D1 Submission: Design Concerns.

D1 Submission: More Concerns.

Photovoltaic Development Partners GmbH
Kurfürstendamm 52
10707 Berlin, Germany

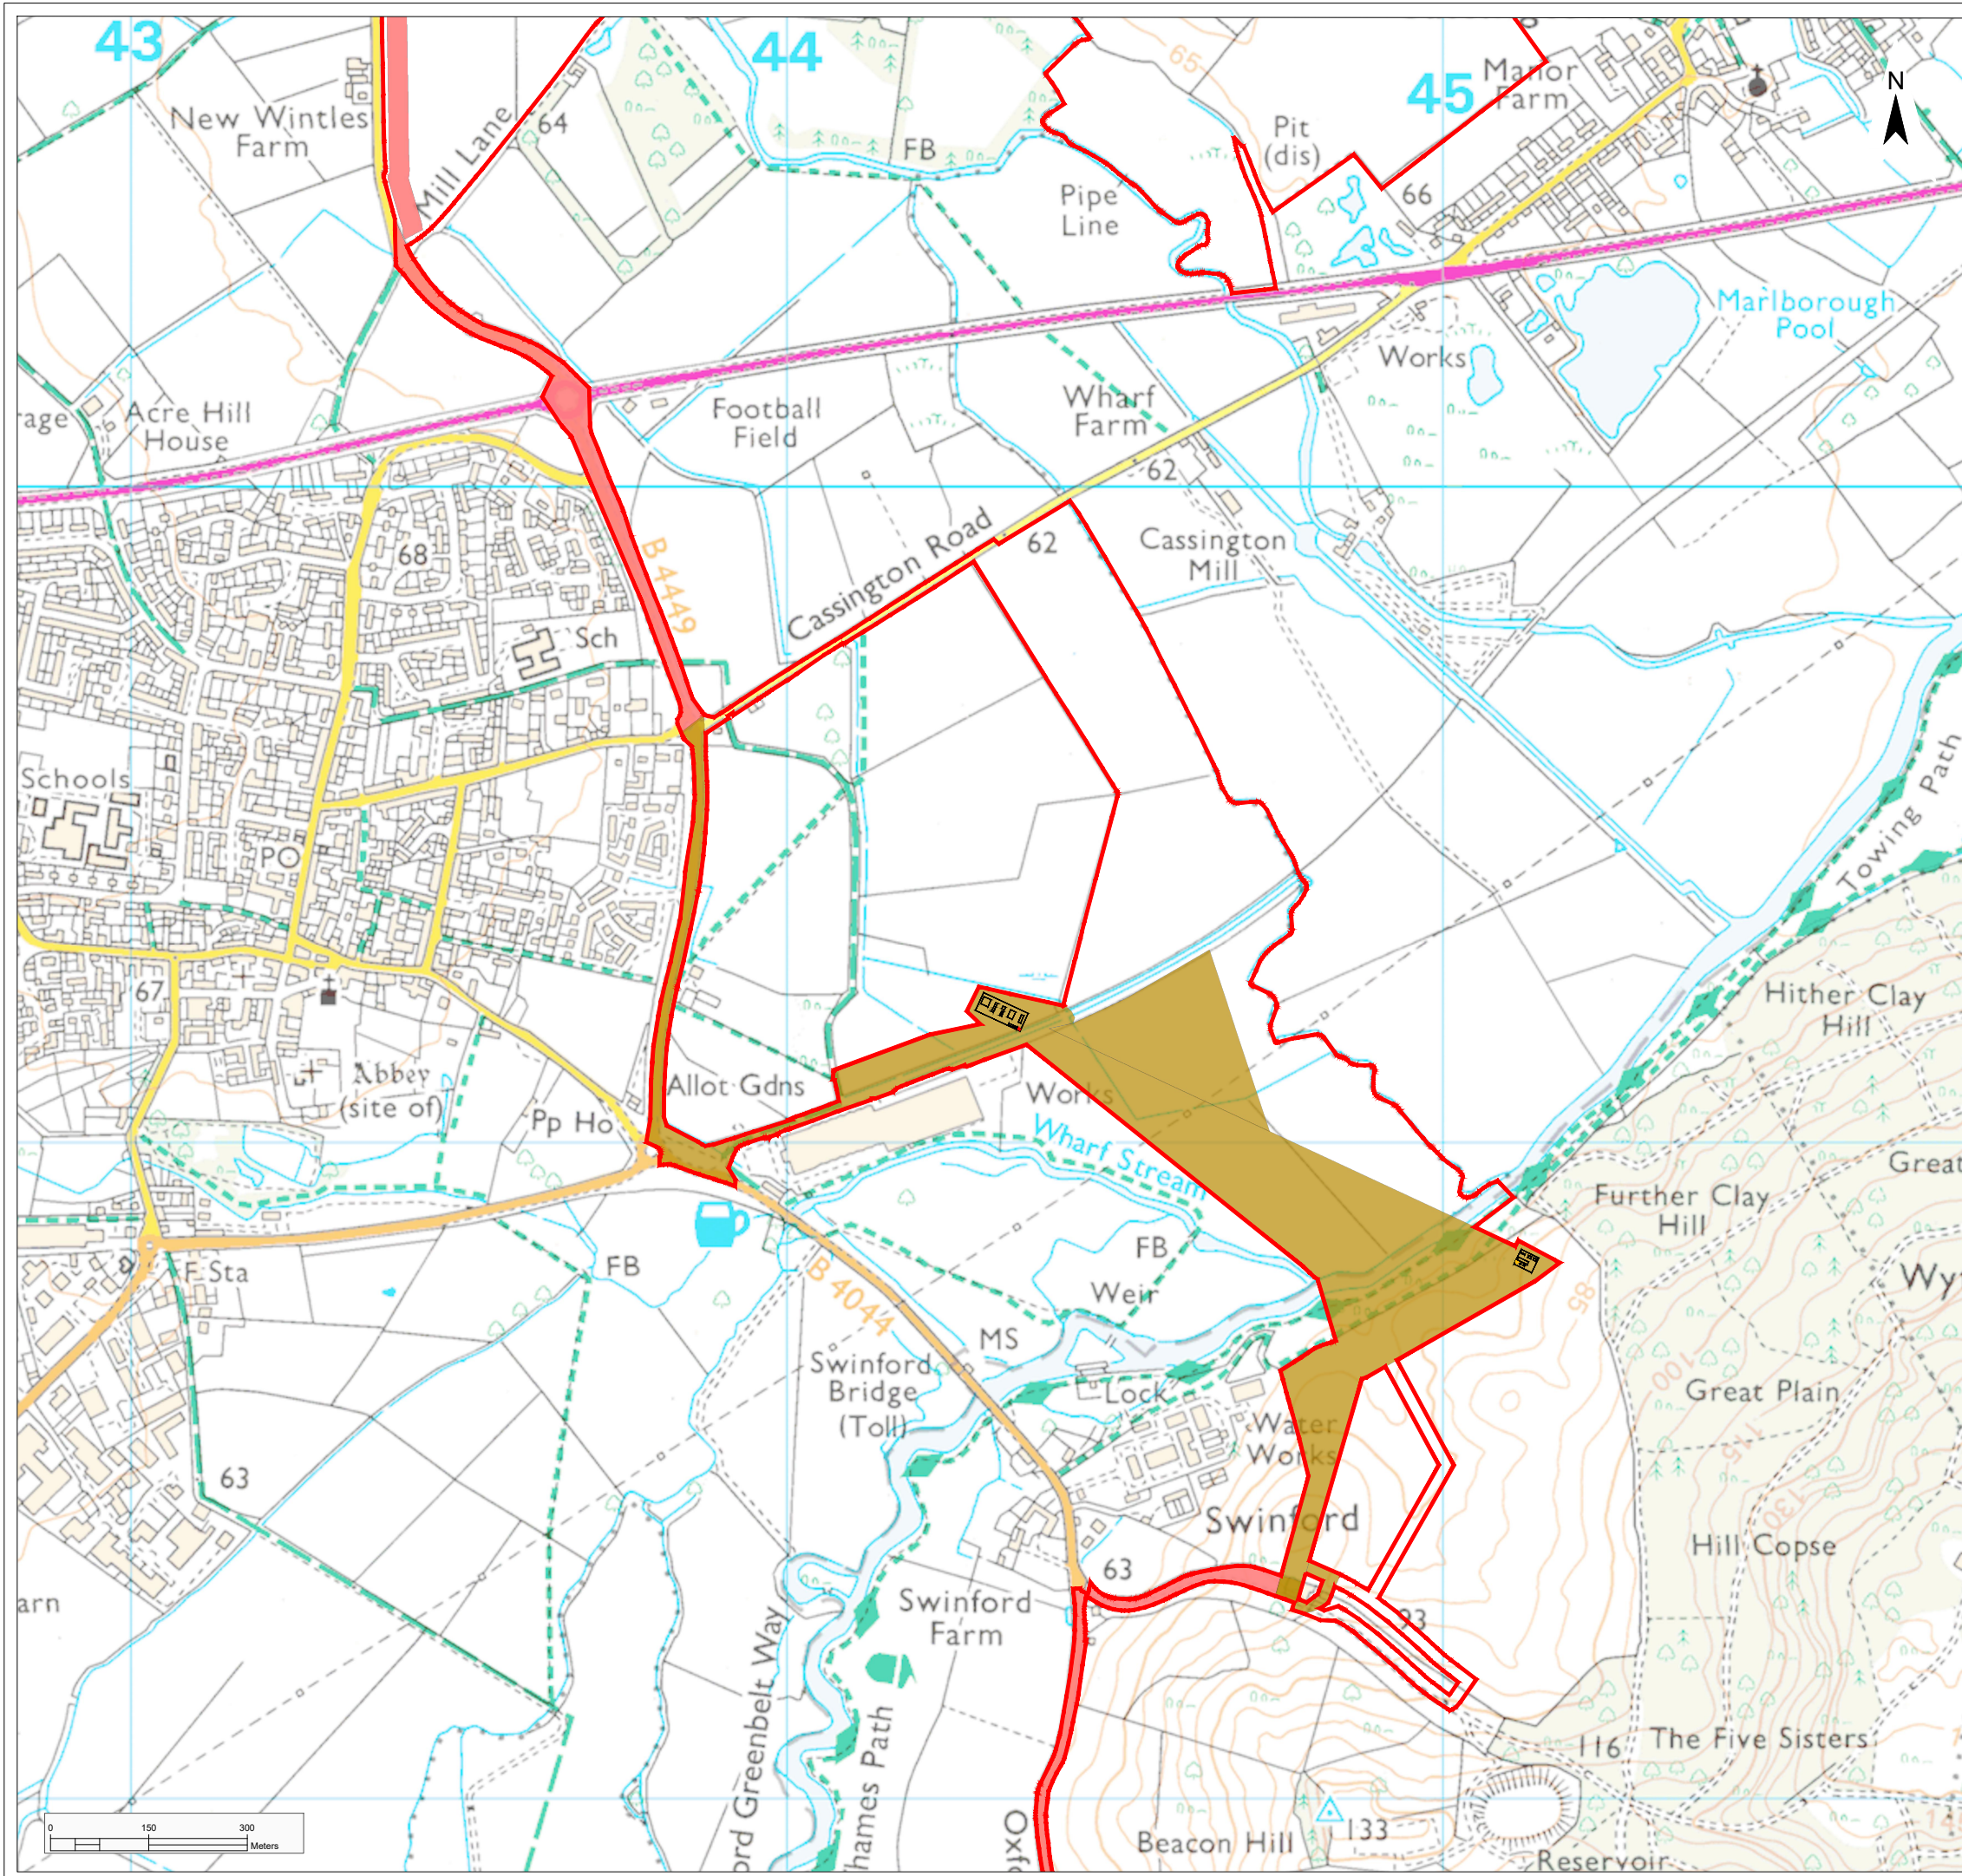
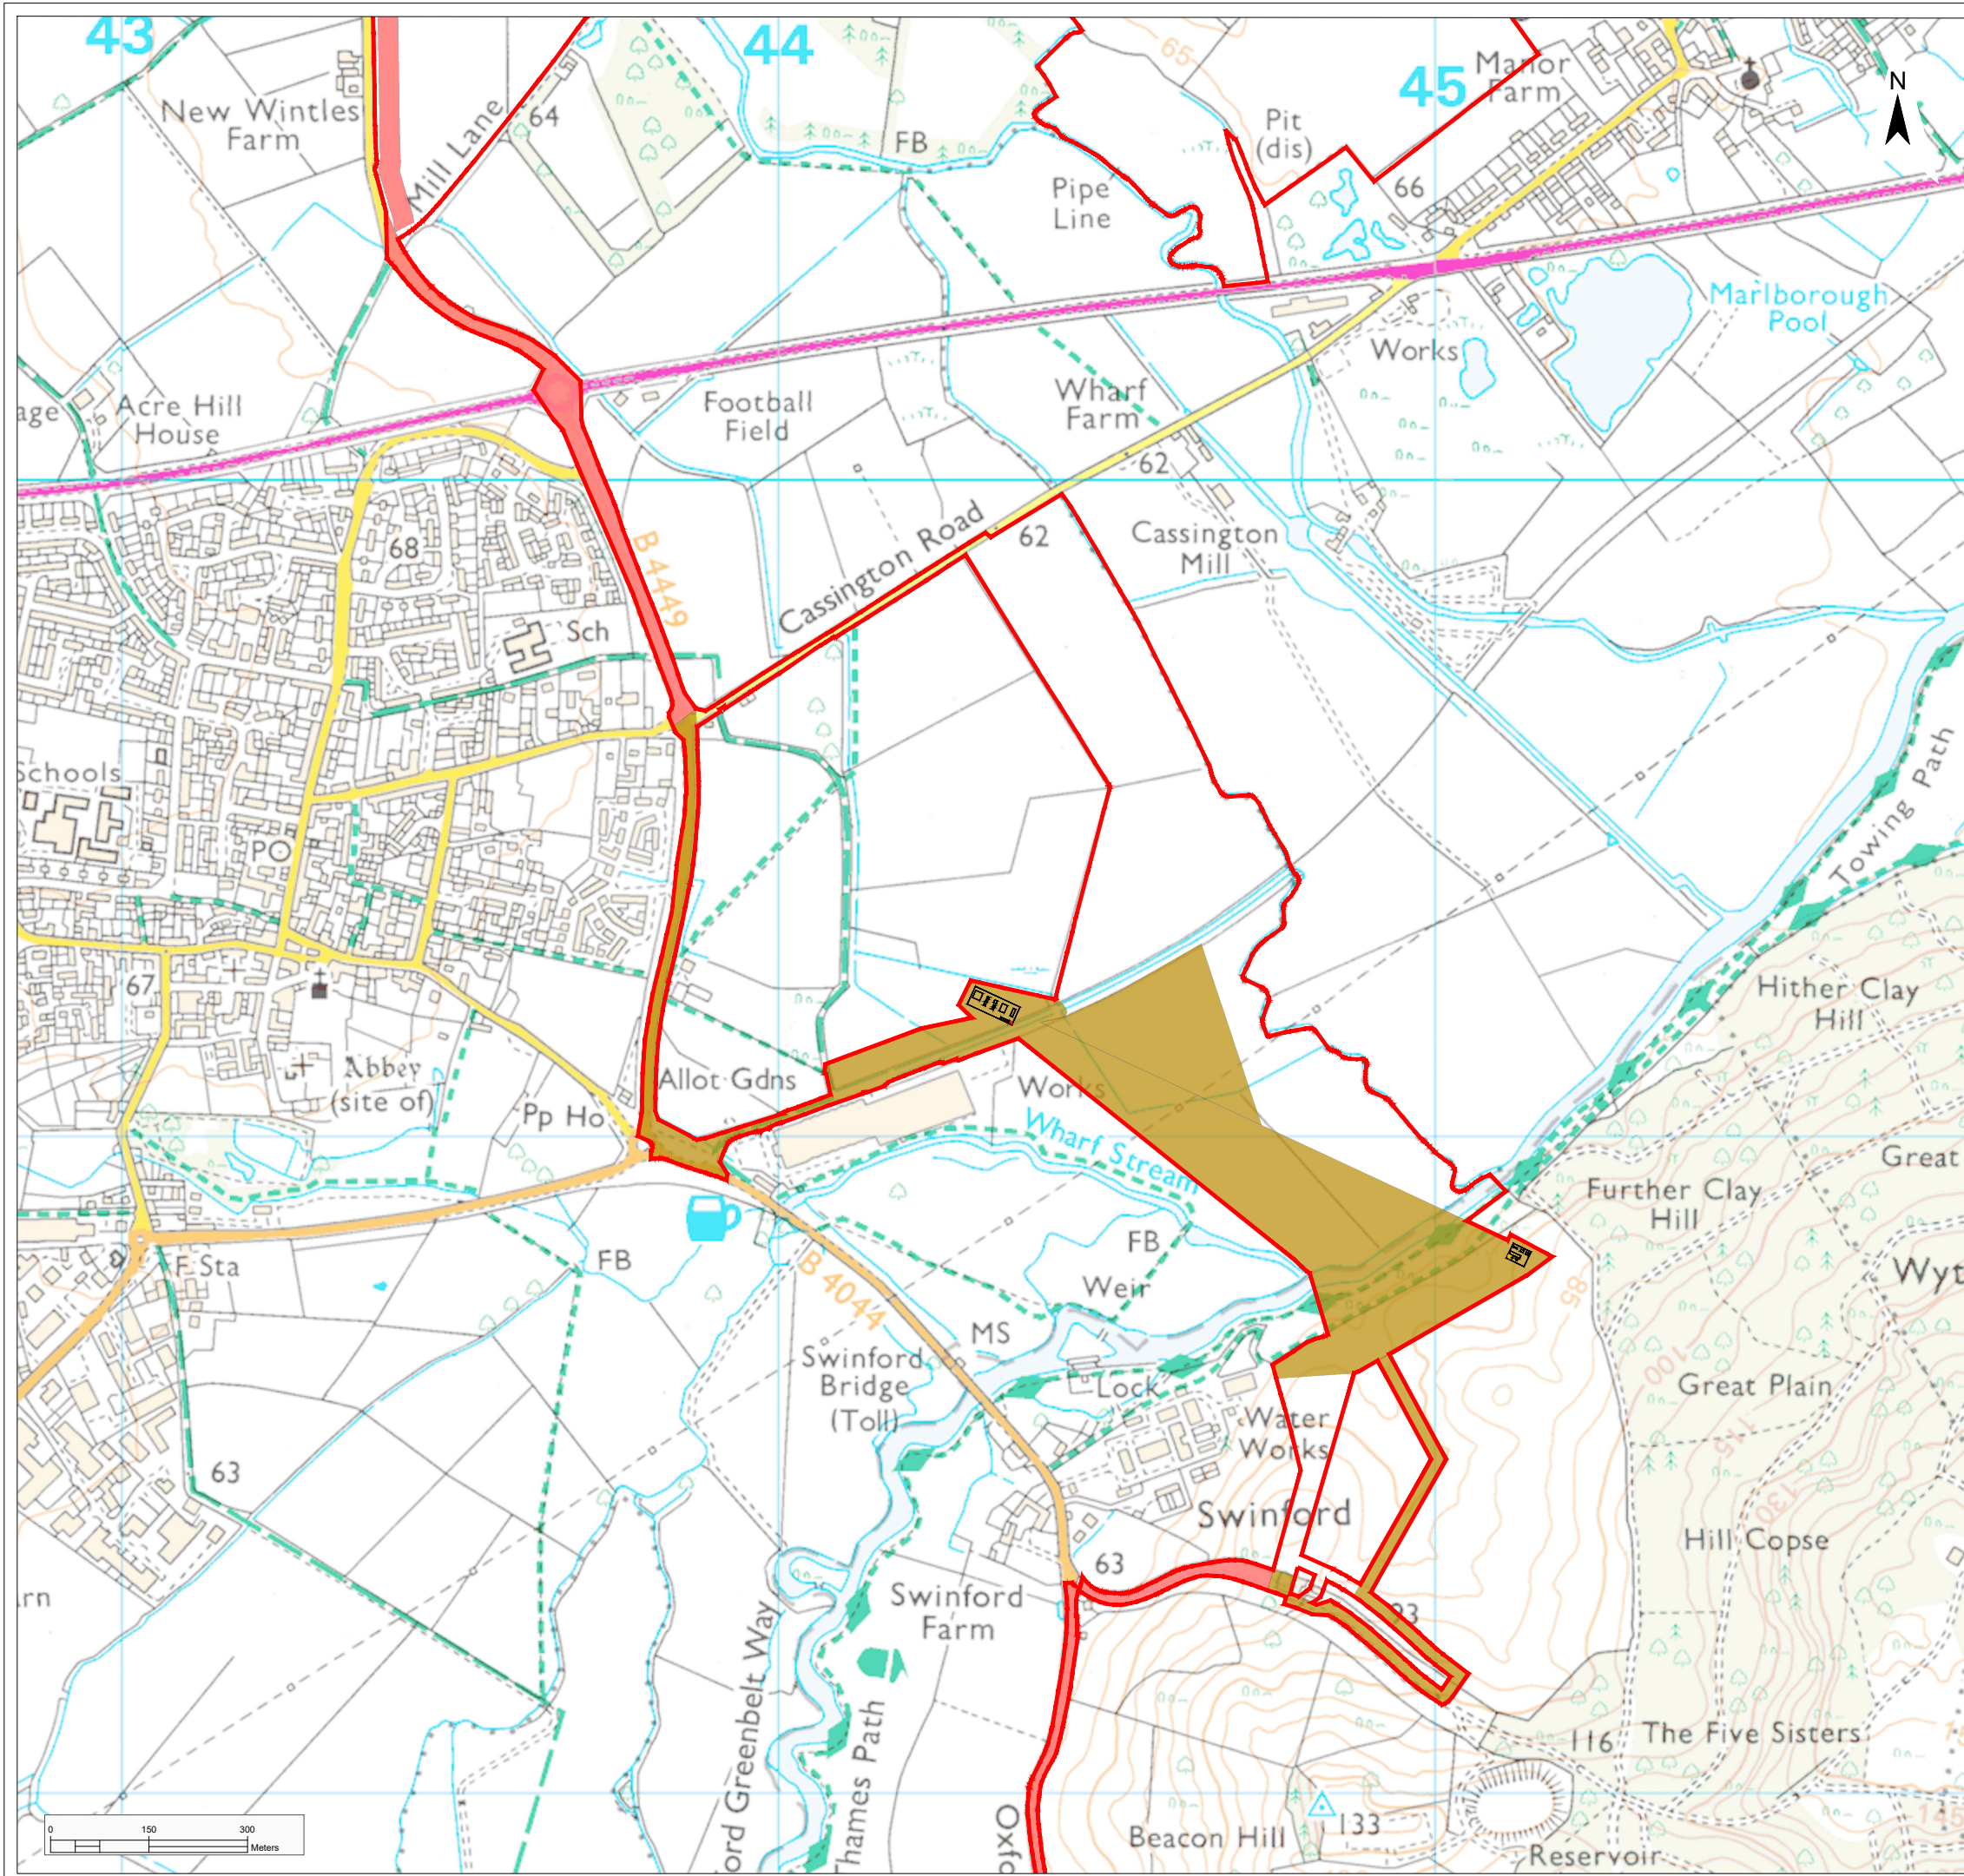
1) There are many ultra-short tables (e.g. **1** and **2** in the diagram). The Scoping Report gave a minimum table length of 14m. Project Description reduced this to 3m. Table **1** looks like a single panel width: 1m.

2) The Masterplan also shows the network of roads (**R**) than run around the perimeters and across the fields. These are coloured grey here but are described as 'grass with occasional matting' or 'natural ground surface' [[OOMP](#), p6]. Are these sufficient to support the weight of emergency fire tenders year-round? Has Oxfordshire Fire and Rescue been consulted? The roads look a bit narrow for the job (2.5m), and the turn radii are certainly far too tight to be negotiated by a fire tender. Should some panels be removed to relax the radii?

3) The north-south table gap is specified in Project Description as between 1.5m and 3.0m; the gaps measured on the Masterplan are 1.5m (panel:gap ratio 3:1).

4) Similarly, Table 6.3 of Project Description specifies a minimum distance of 7m between the fencing and the solar tables, whereas the Illustrative Masterplan shows PV panels consistently packed in with a fence separation of less than 5m.
